January 23, 2025

**Re: QuikTrip 7001, Albuquerque**  
**Matkin Hoover Job No. 7001.01**  
**DFT PRJ # PR-2024-011229**

This letter and its attachments serve as a response to comments received on Dec 16<sup>th</sup>, 2024, concerning the above reference project.

SHEET NUMBER:  
**C150**  
14 OF 25

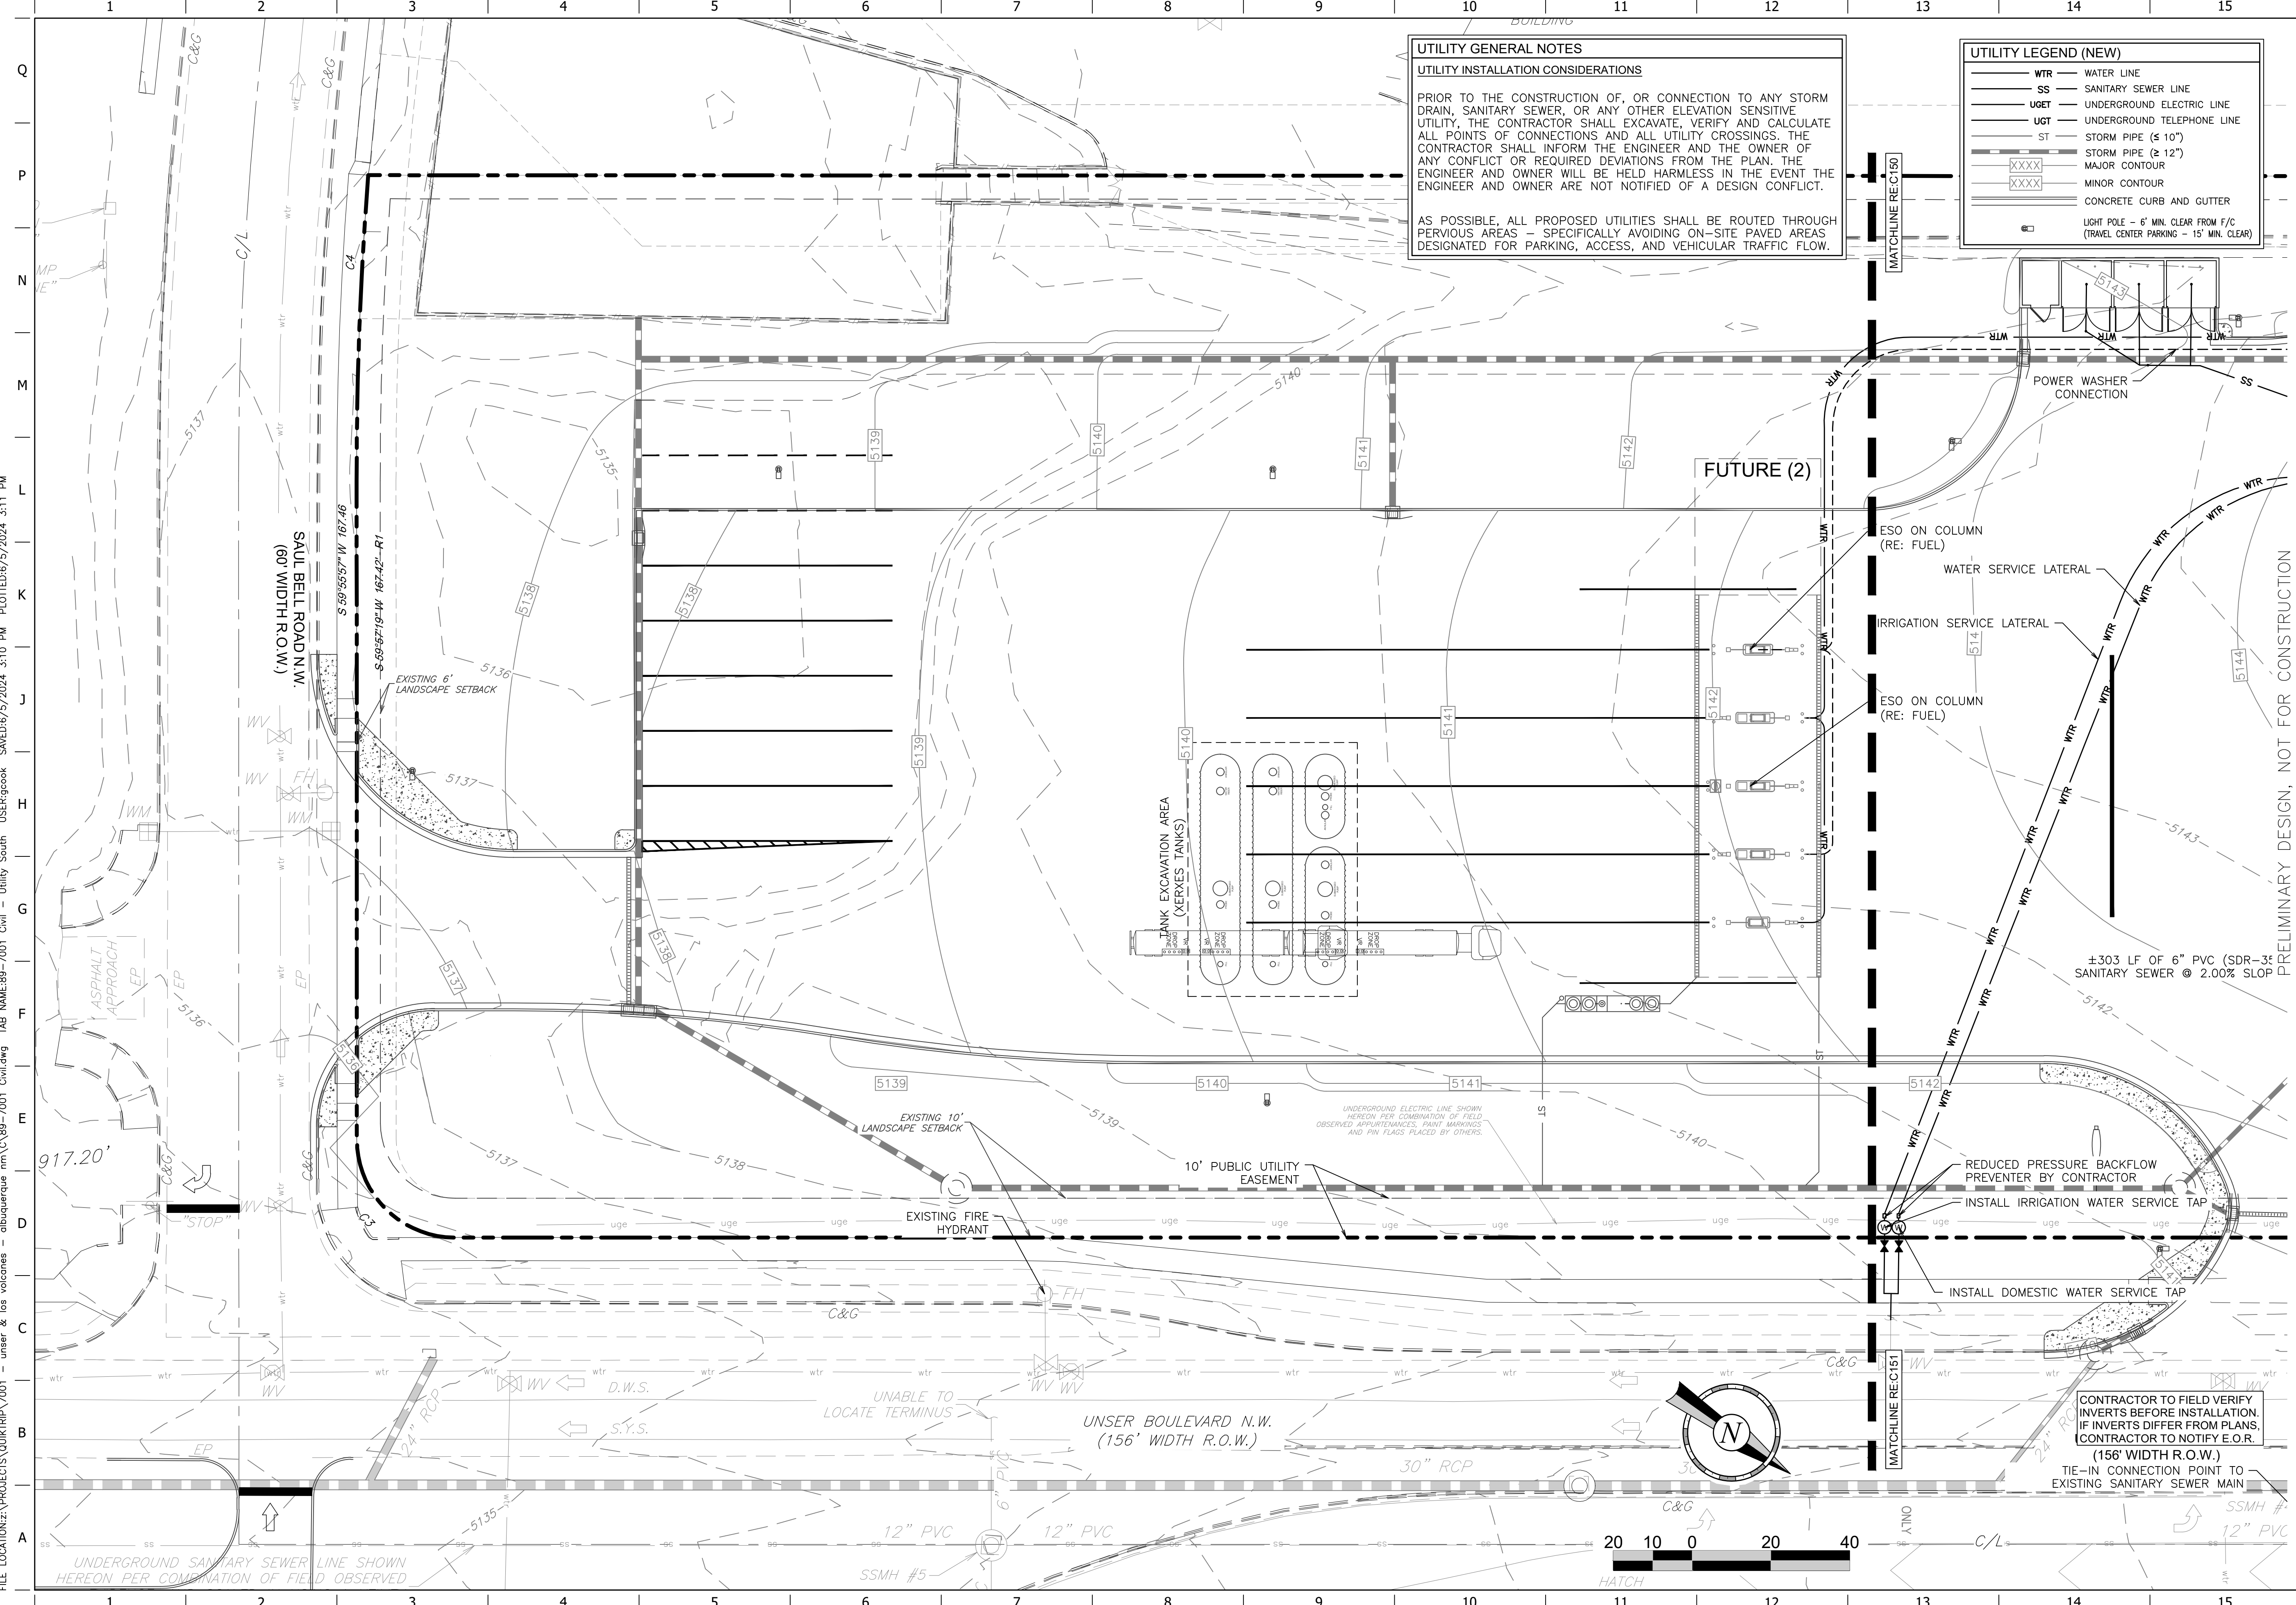
Dimension the public water and public sewer easements on the utility plan.

There shall be no trees, parallel fences/sidewalks/curbs, or structures within the public water and public sewer easement. Please revise accordingly.

Each service connection must have a separate connection perpendicular to the main domestic waterline. Manifolding of services is not permitted.

Please show the metered services within public right-of-way.

Please label everything public or private and note all proposed public infrastructure will be constructed with a Connection Permit or other if Work Order.

Concur. Utility Easement Callouts added to both north and south utility plans.

Concur. All trees, parallel fences, and structures removed from all related public water and public sewer easements onsite.

Concur. Service connections adjusted to be separate.

Concur. Meters adjusted as requested.

Concur. Service laterals designated as requested.
